**Section 96 (1A) to amend SSD 6848 in respect of the façade and height of Lismore Hospital Stage 3B**

On 1 May 2015, Stage 3B of the Lismore Hospital redevelopment was approved. Since that time, detailed design has been undertaken and minor amendments are proposed to both the façade materials and the height of the development.

Drawing No. WEST ELEVATION - 3B2
 Checked: AJ
 Approved: GS
 Date: 1:100
 Scale as original

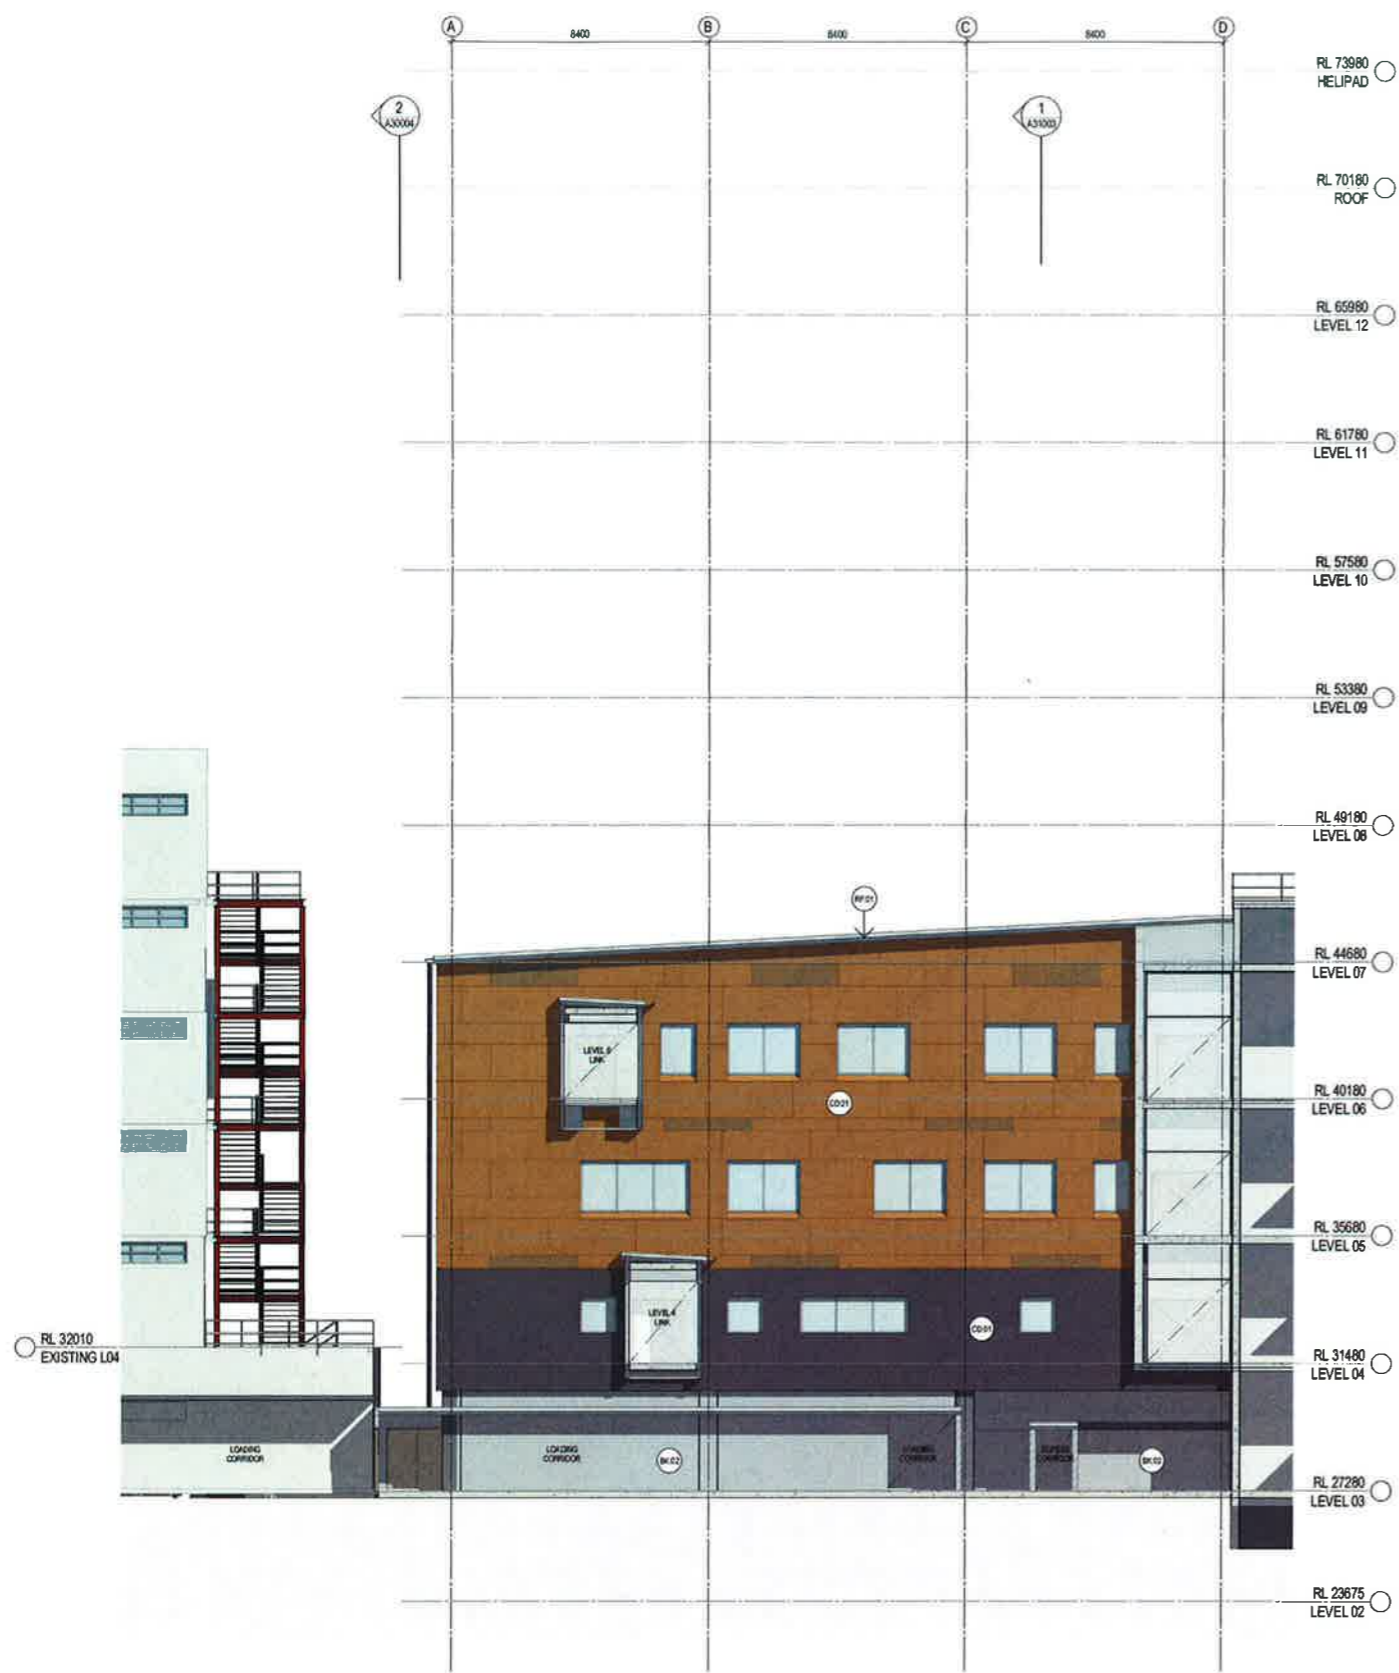
The change to the panels on the façade have been made due to availability and durability and the outcome of the material change is considered to be a beneficial to the overall visual outcome of the building.

The panels that have been chosen for the façade differ slightly from those shown in the application as a different brand of panel have been specified which does not match the exact colour approved. A comparison of the two products is shown in the attached letter from City Plan Services and Development (City Plan) (Attachment A) who has prepared an assessment of the planning merit of the product specified.

In addition to the changes in the materials identified above and in the attached report, the overall height of the 3B2 building has been reduced by one floor due a revision of the scope. This change has no impact on the function or operation of the building or on the surrounding environment.
